**Planning application no: 2021/94552**

**Land at, Barnsley Road, Denby Dale, Huddersfield HD8 8TS.**

**Erection of 53 dwellings and associated works**

**Comments for inclusion in the public consultation relating to the above planning application.**

Appendix 1: Notes on Drainage Strategy

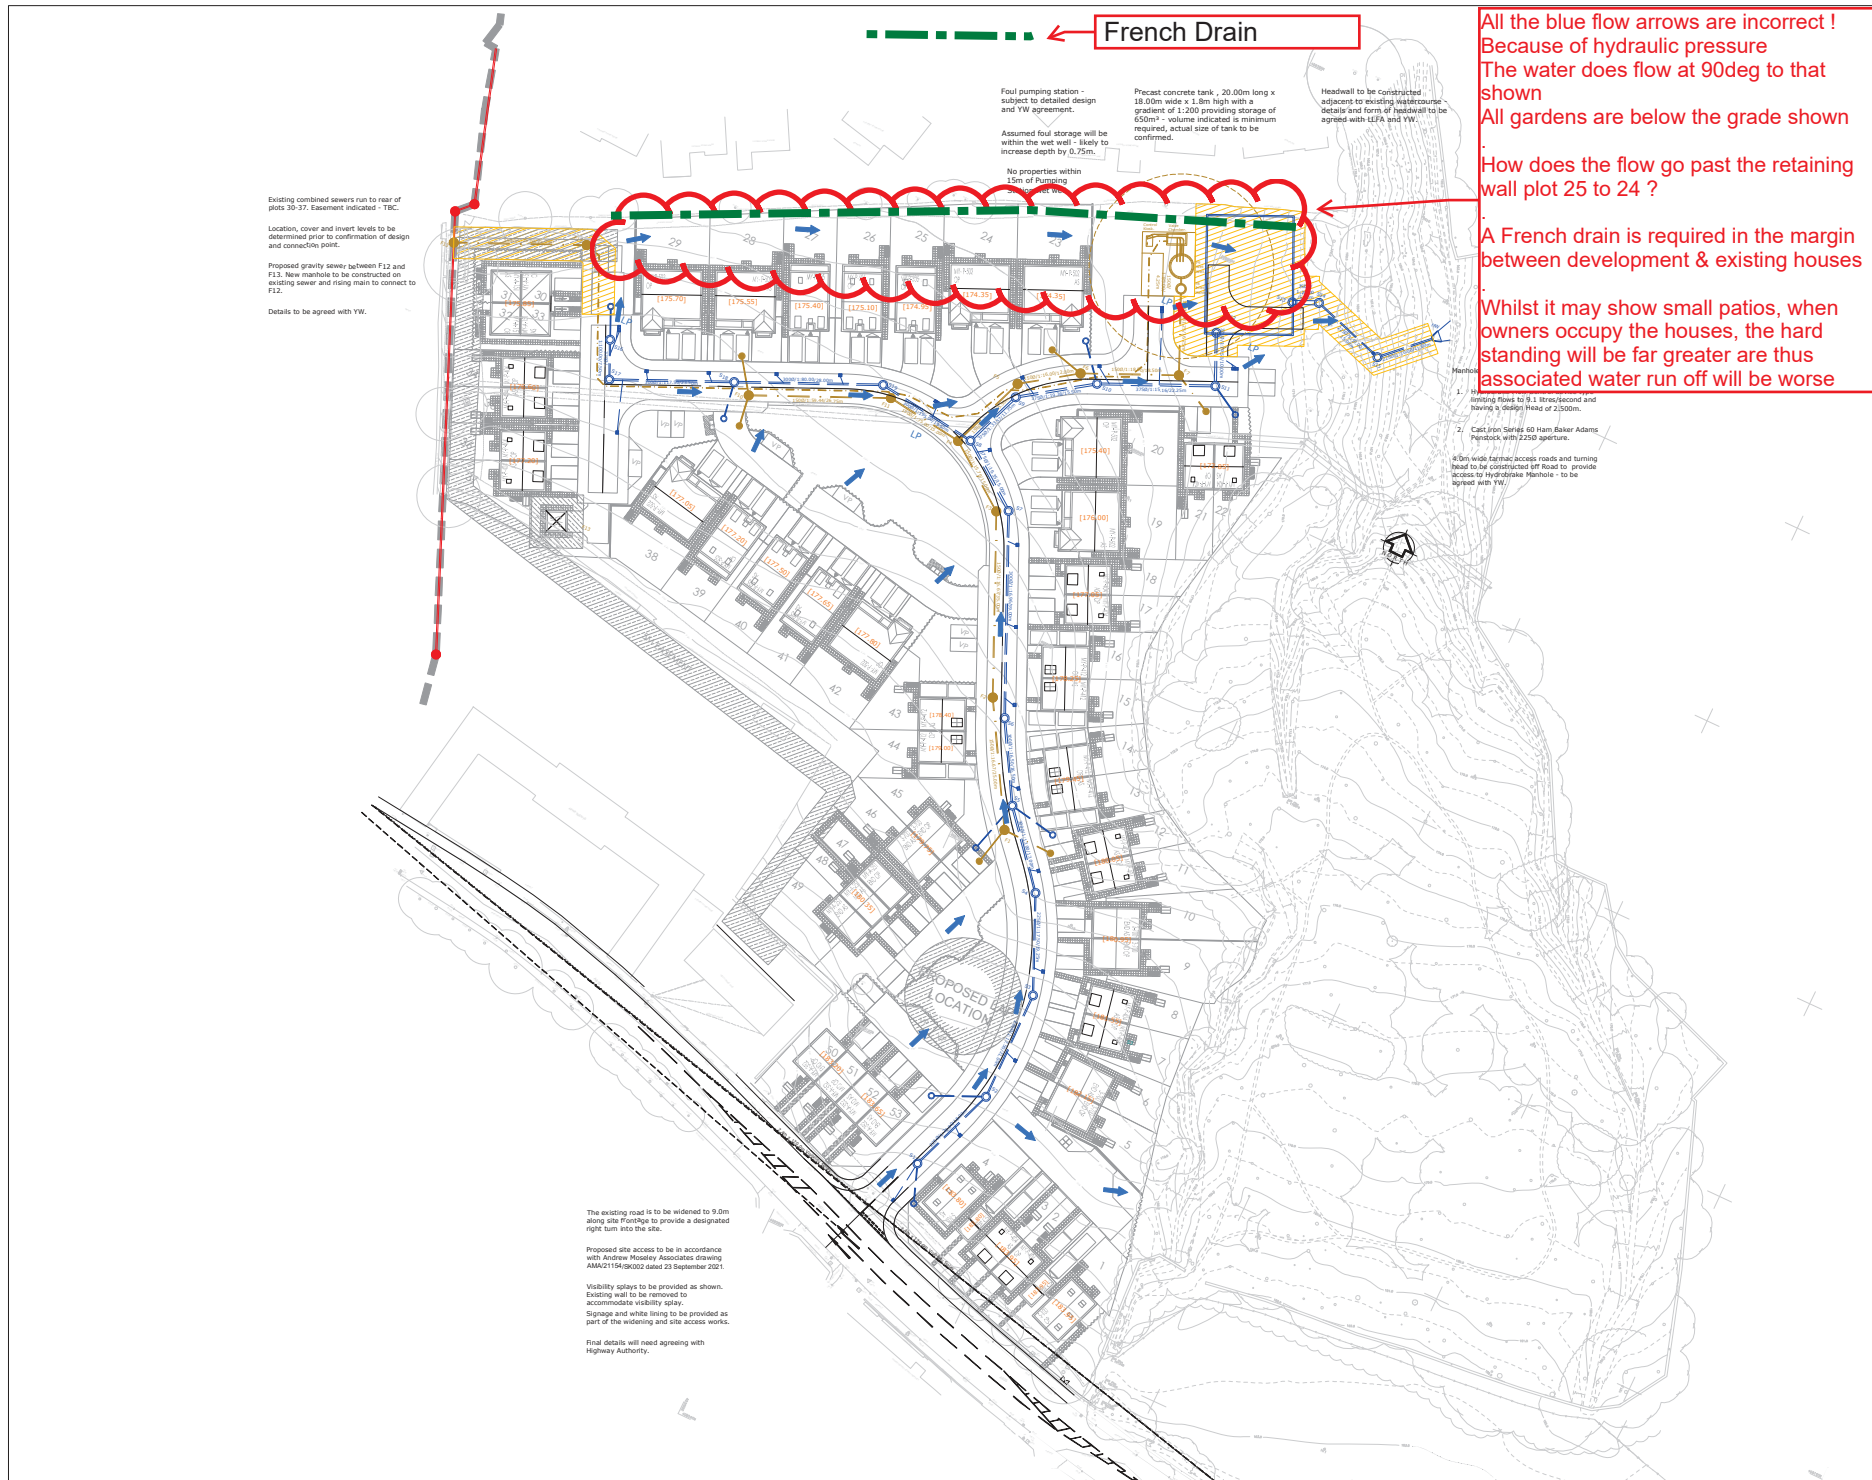
- c) The Drainage Strategy Plan (ref 5212-C-D-9-03, page 31 of Geo Structures Civils Flood Risk Assessment & Surface Water Management Strategy id908369) shows surface water running west to east along the northern boundary – see Appendix 1. For this to be effective the datum of the houses needs to be at 172.00

Given that the rear gardens of the proposed housing nearest this boundary slope markedly toward the northern boundary (more so than currently), it is impossible for surface drainage water to run in an easterly direction toward Tanner Wood as suggested on this plan.

Furthermore, boundary walls between the gardens of the new properties run north to south down toward the northern boundary. Hence, surface run off from this area will be further forced directly into the gardens of the existing properties north of this boundary.

A French drain running along the northern boundary is therefore a minimum requirement. (See Appendix 1) and the level of the new houses along the northern boundary should be lowered to reduce run off (See also section 4a below).

Appendix 2: Proposed Amend to Street Scene Schematic

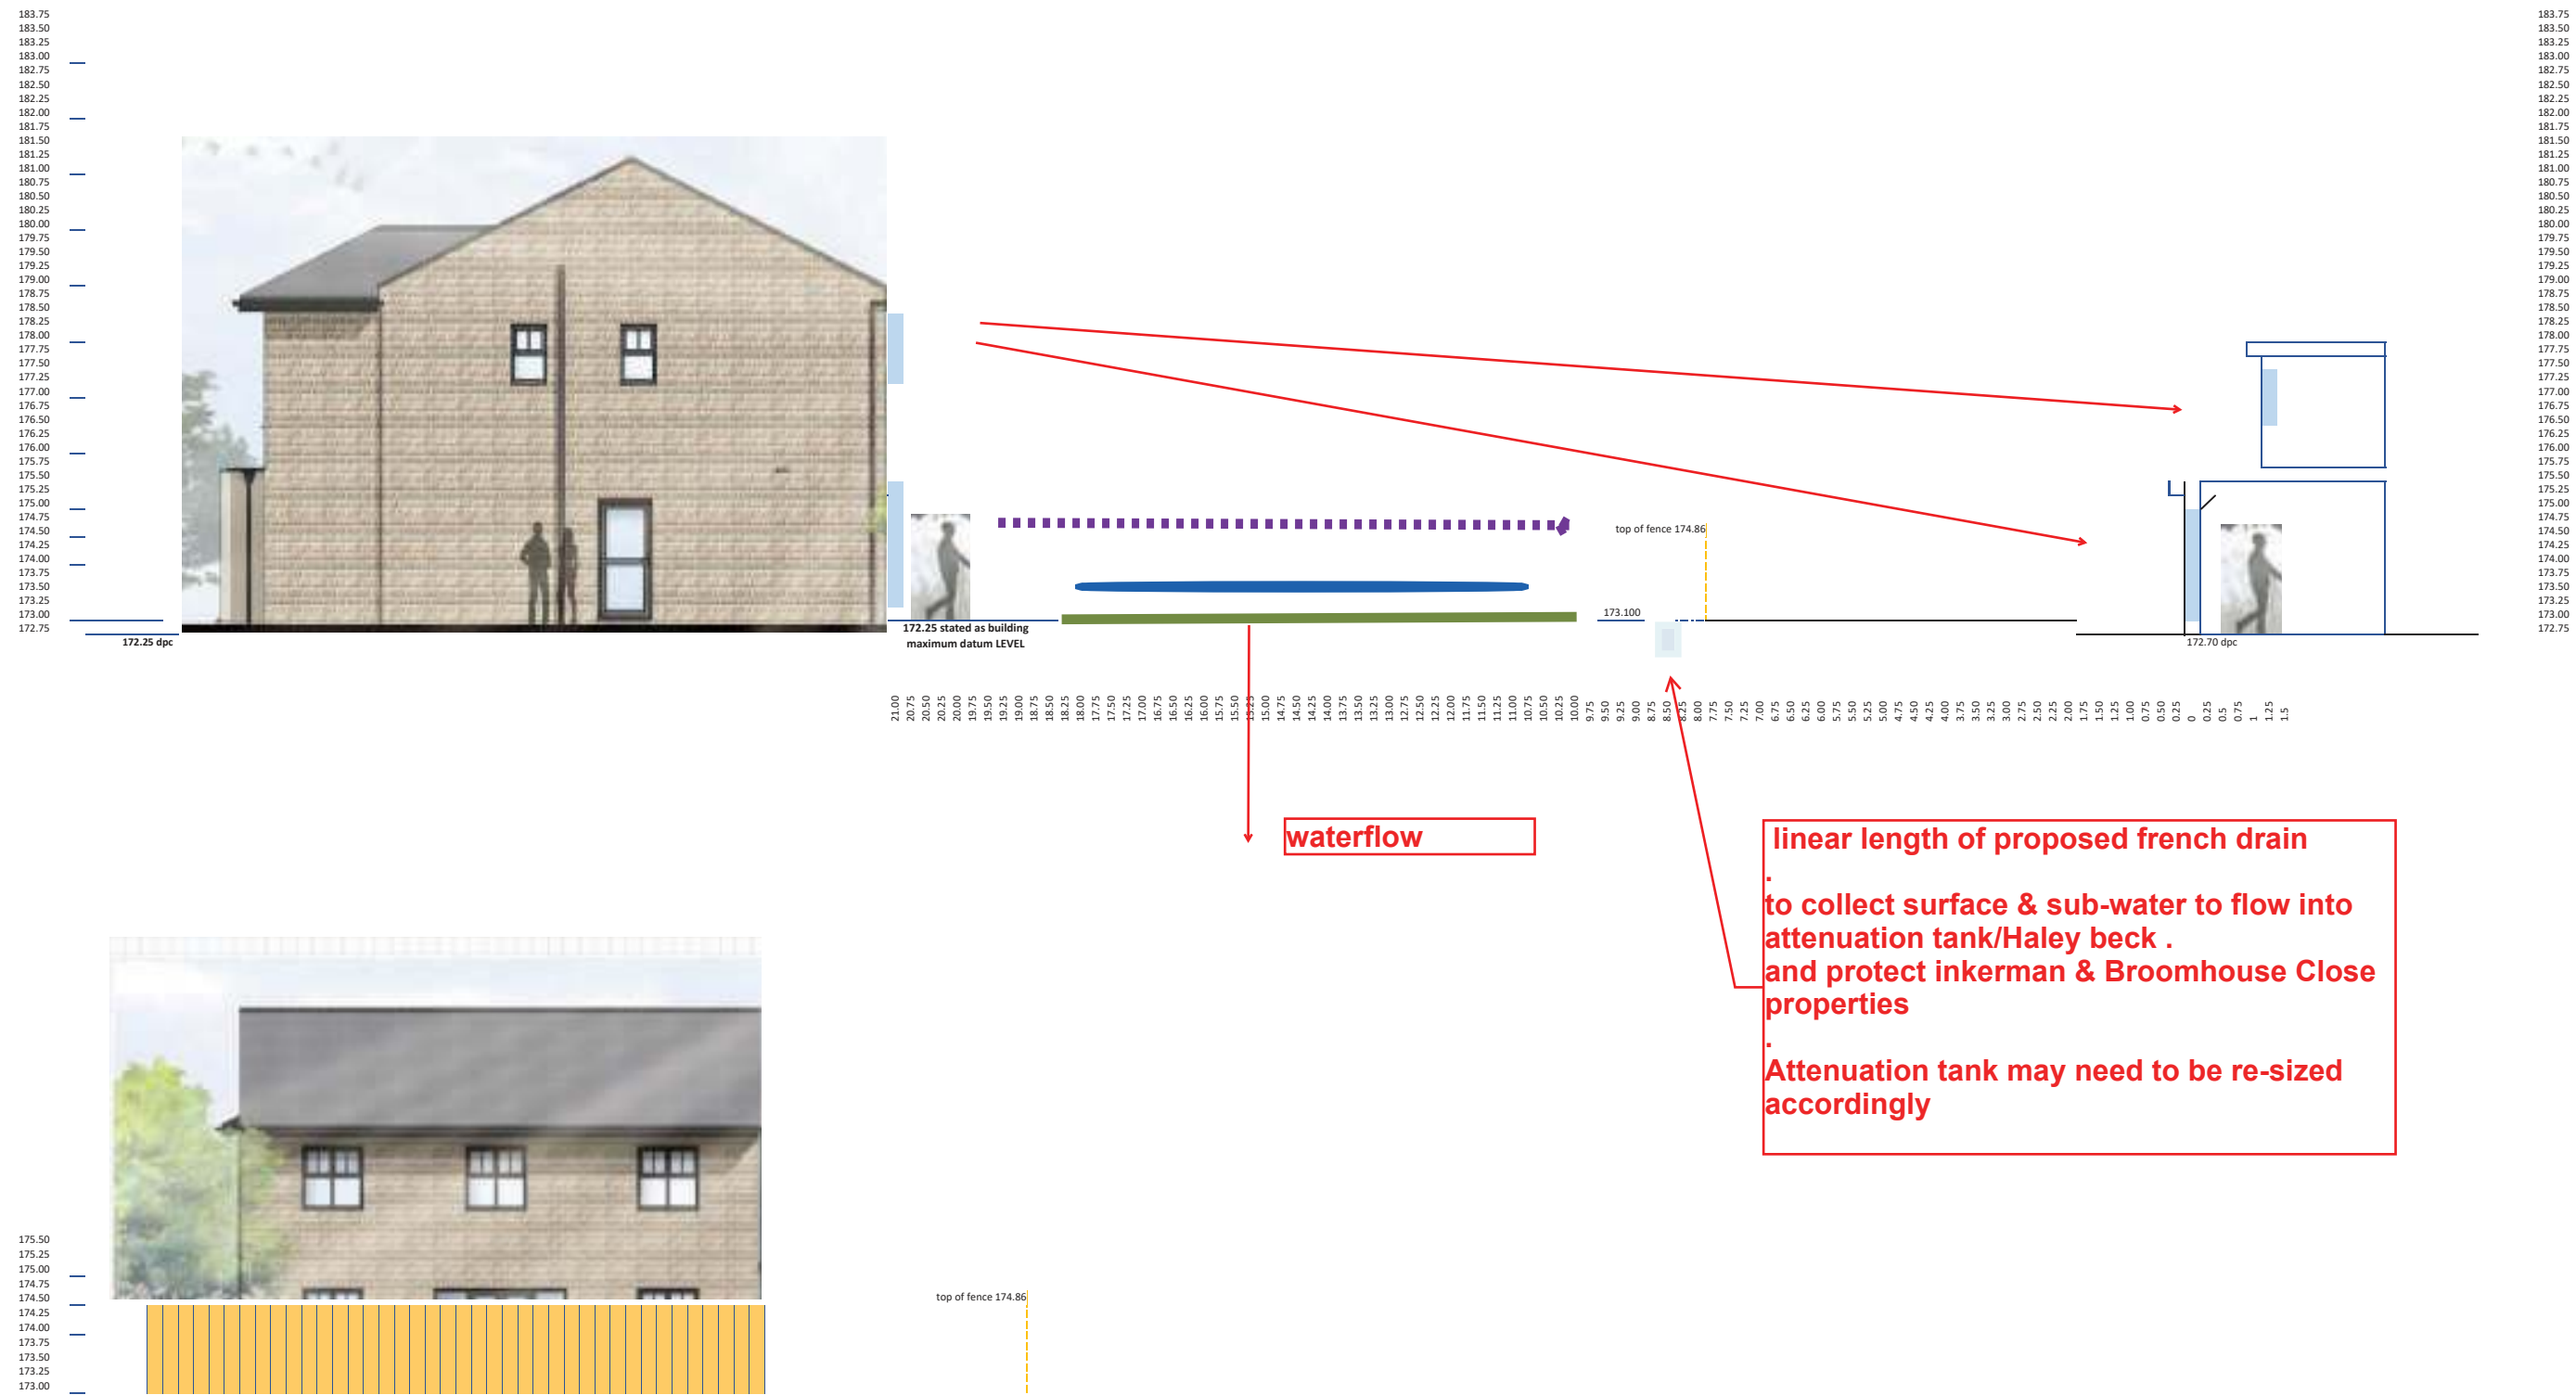
- e) Key street scenes are missing on the application drawings (See Strata Street Scene schematic: ref 21-CL2-SEGD-BRDD-10). Hence, the A-A section needs to be extended to A1 (See Appendix 2) in order that the houses in Broomhouse Close are shown with the associated overlook issues as, detailed later in section 4a of this commentary. Refer also to comments in (b) above

Similarly, the marked D-D & D1-D1 sections on Appendix 2 should be added to the plans to highlight the extent of overlook onto the existing properties on Inkerman Way and Broomhouse Close on the northern boundary.

Missing Elevation on plans Elevation DD

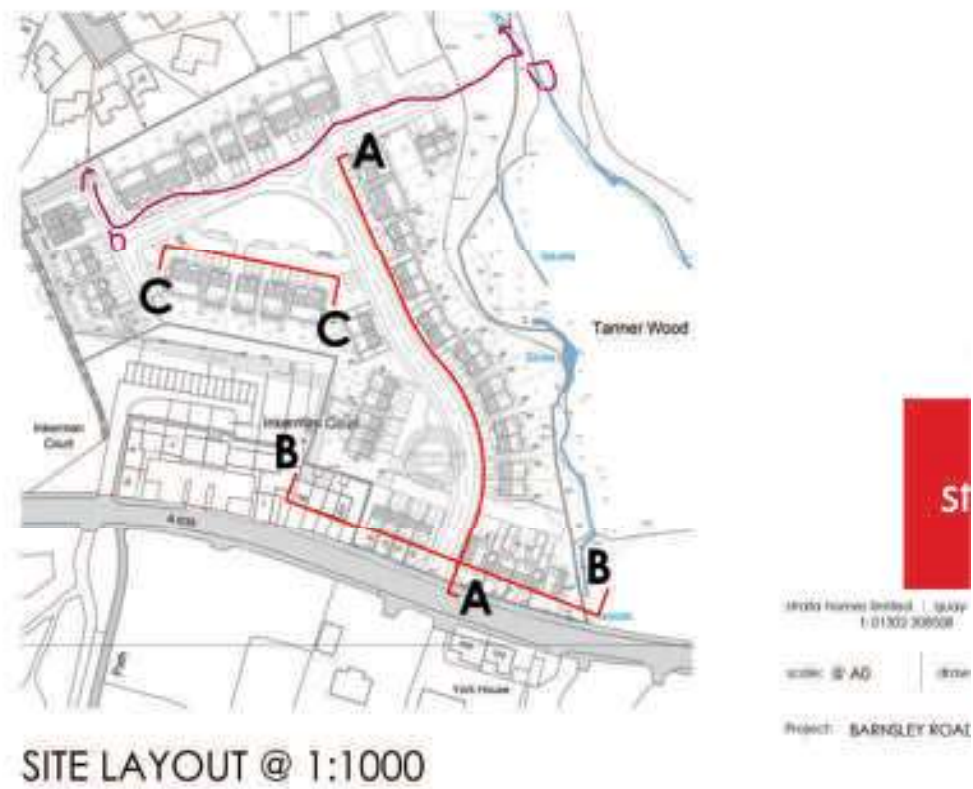
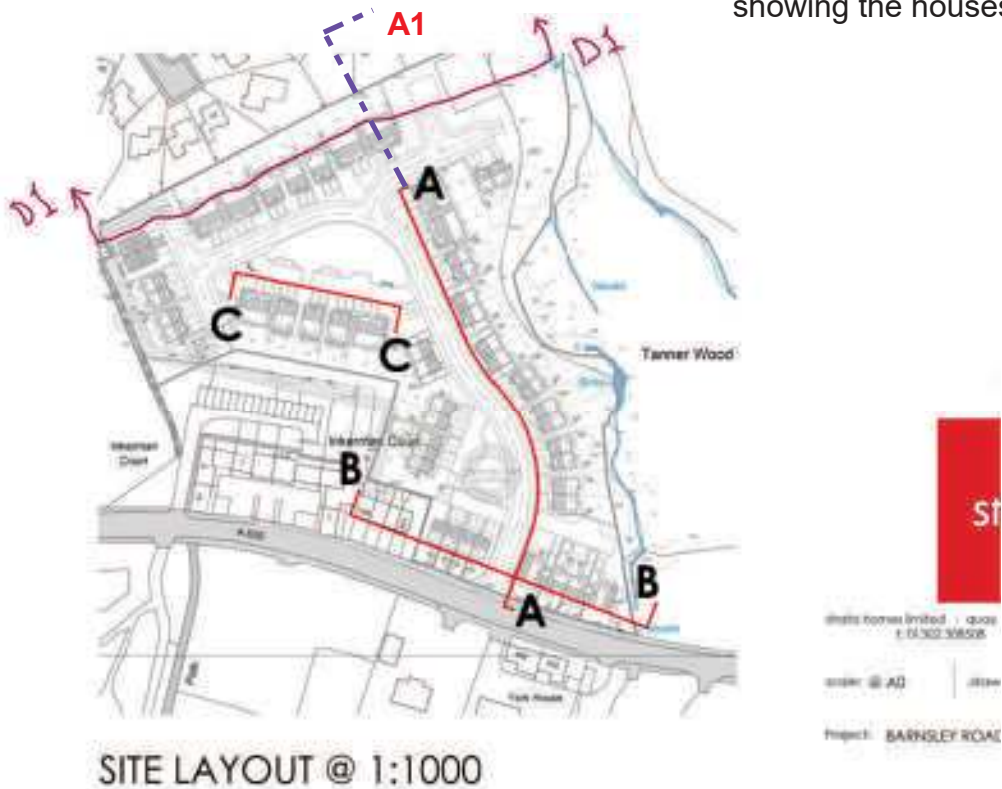
This is especially given that the elevations shown in the ID Civils Engineering Feasibility Layouts: ref 5212-C-D-9-01 & 02 id908371/2 show that the rear of new houses on the northern boundary are potentially being built on made up land at a height appreciably above the existing elevation levels of the site, further accentuating overlook issues. In particular, the levels of plots 27-29 are critical relative to house numbers 19-25 Inkerman Way and we would request site sections are provided across this part of the site. It would appear that the ground floor level differences between these houses are in excess of 3m which is clearly unacceptable.
